From: Amy Myer <Amy.Myer@arun.gov.uk>
Sent: 25 June 2020 09:44
To: Planning.Responses <Planning.Responses@arun.gov.uk>
Subject: FW: AL/34/20/PL & AL/35/20/L - CONSERVATION COMMENTS

AL/34/20/PL & AL/35/20/L

Norton Farm House Norton Lane Aldingbourne PO20 3NH

Subdivision of existing building to create 1 NO. 1- bed dwelling & construction of 4 bay oak framed outbuilding as a garage. This application affects the character & appearance of the Norton Lane, Norton Conservation Area & affects the setting of a Listed Building.

EAST ELEVATION TO COURTYARD

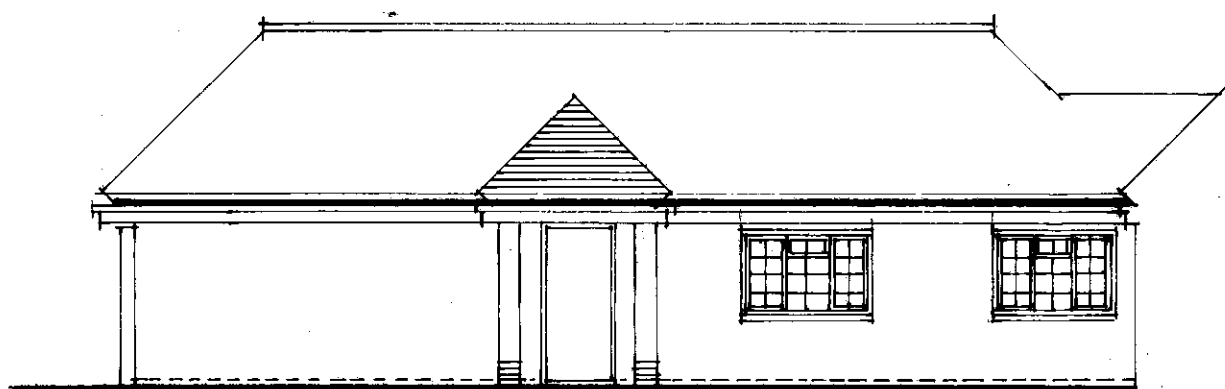
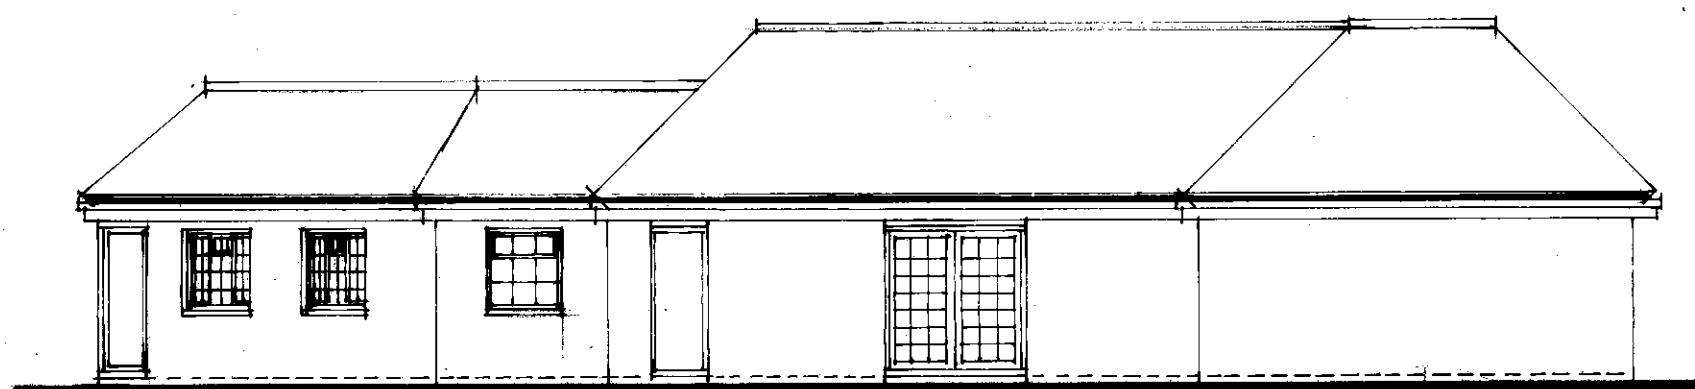
This element of the proposal affects a late C.20 extension which is located to the side of the main listed building. It is noted that the interior of the space will not significantly alter. Externally, a new entrance door and porch would be constructed to provide access from the south courtyard and a window would be replaced by a pair of French doors on the west elevation. Such alteration will not harm any historic fabric, and their success will depend upon their appearance and construction.

Details of the proposed garden boundary, the new joinery and their treatments should be provided by way of condition if you are minded to approve the proposals.

SOUTH ELEVATION

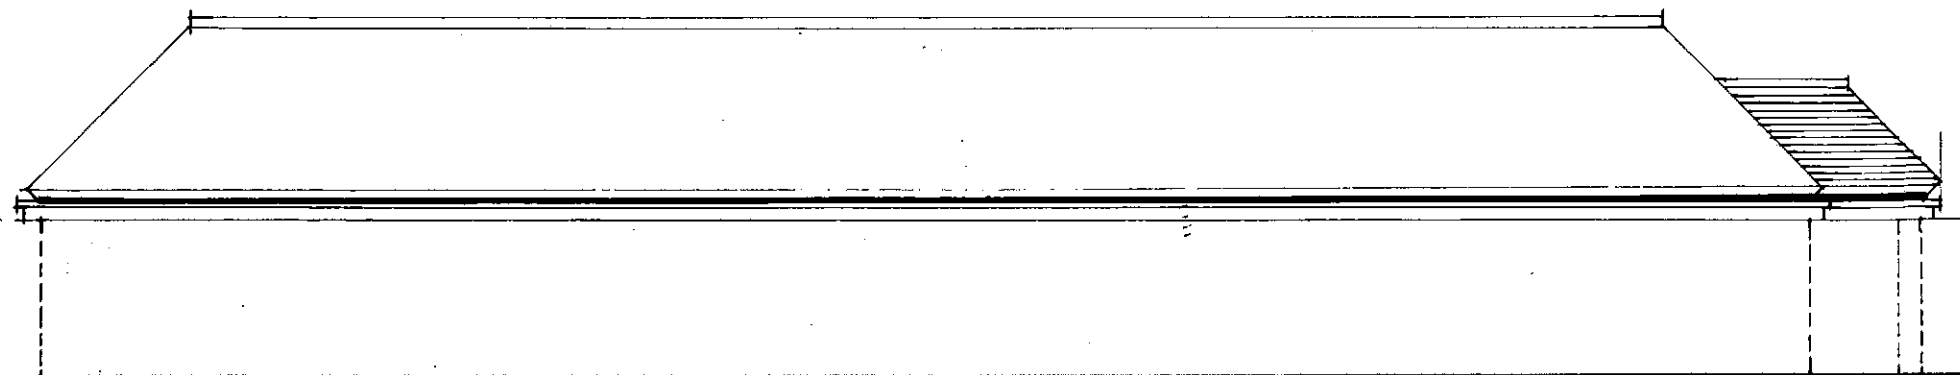
The separate detached structure appears to be generally acceptable. The use of hand-made tiles to match the existing adjacent building and the use of larch feather edge weatherboarding would reflect the character of the building.
